**Major Projects – Affordable Housing (SSD-72700708) – Lot 1 DP 843470; 25-27 Boyd Street, TWEED HEADS (DA25/0057)**

Reference is made to the above proposal and the Department's request for Council's advice/comment on the proposed development. Council officers have undertaken a review of the proponents Environmental Impact Statement and supporting documents and provide the following comments for the Department's consideration. It is noted that Council is generally supportive of such a development and that this would provide much needed housing within the Tweed Shire.

1 Basement Carpark Lvl 2
SCALE 1:200 @ A3

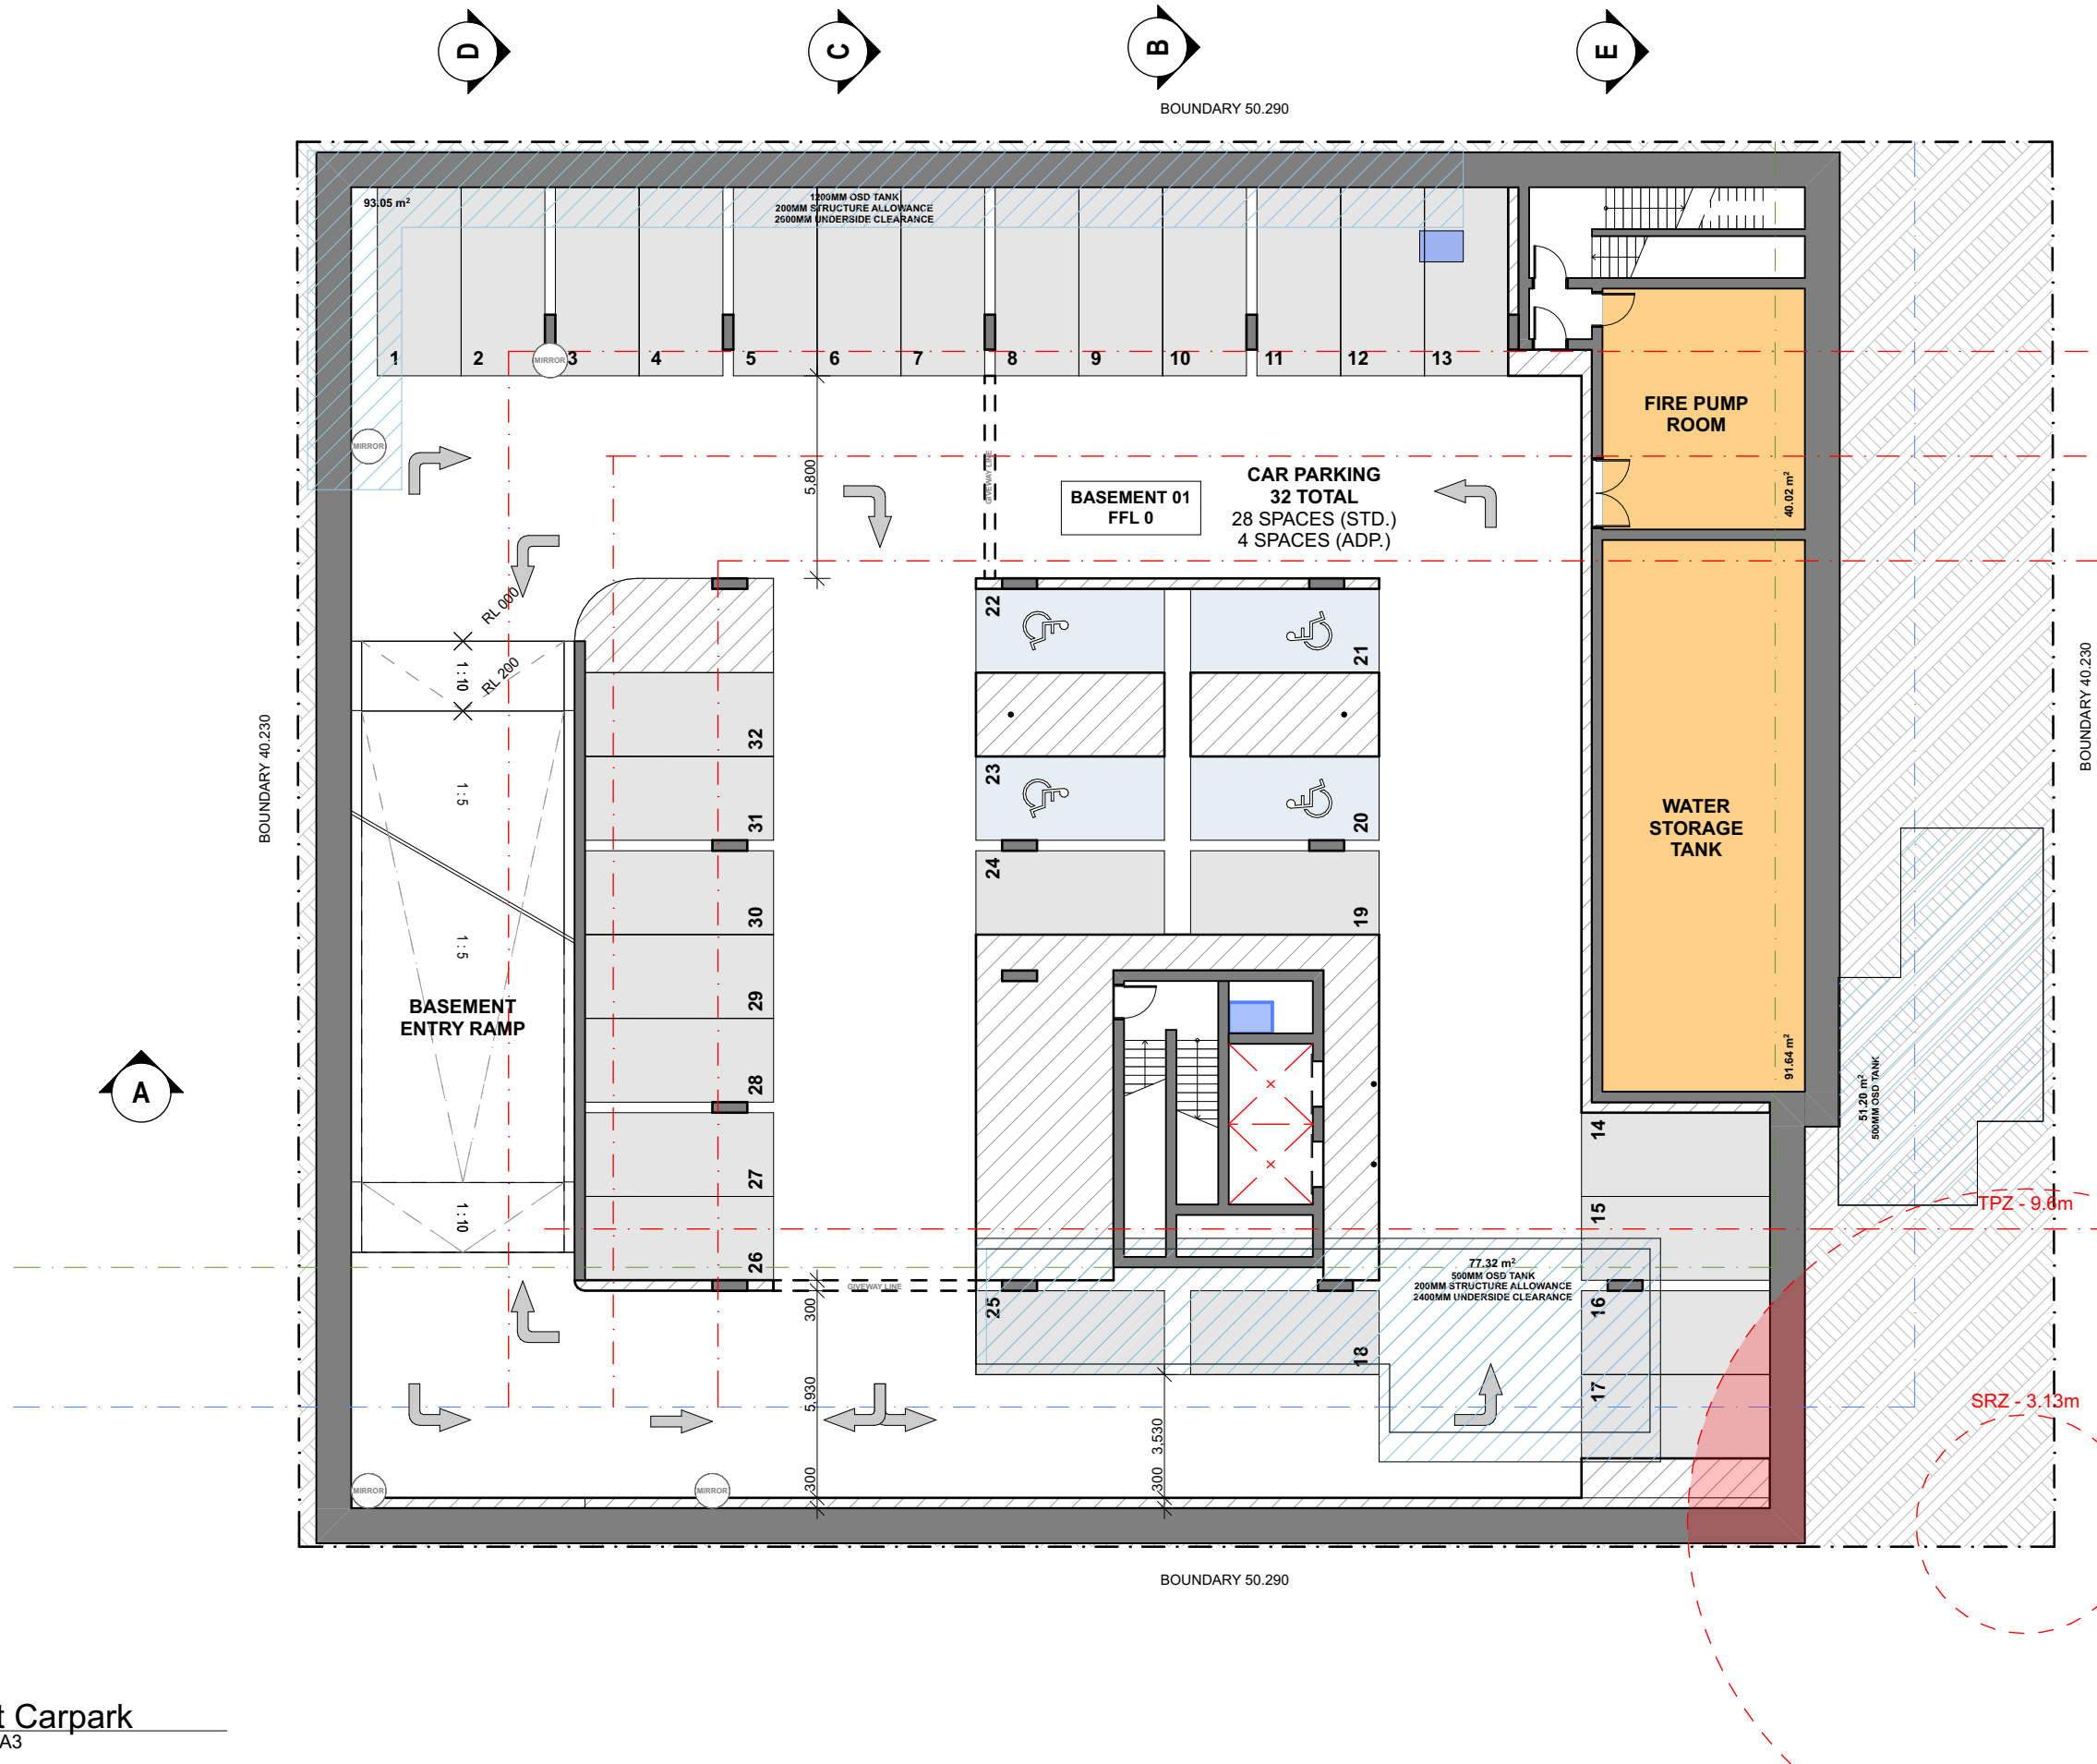
An oil and sediment device with a minimum 0.7m<sup>3</sup> sediment sump is proposed to treat runoff from the basement car parking area (level 1). No provision has been made for stormwater quality for the level 2 basement car park.

The Stormwater Management Report is to be updated to address stormwater quality for both levels 1 & 2 of the basement car parking to comply with Council's Development Design Specification D7 – Stormwater Quality (Section D7.12.1 for pollutants generated from undercover or basement areas).
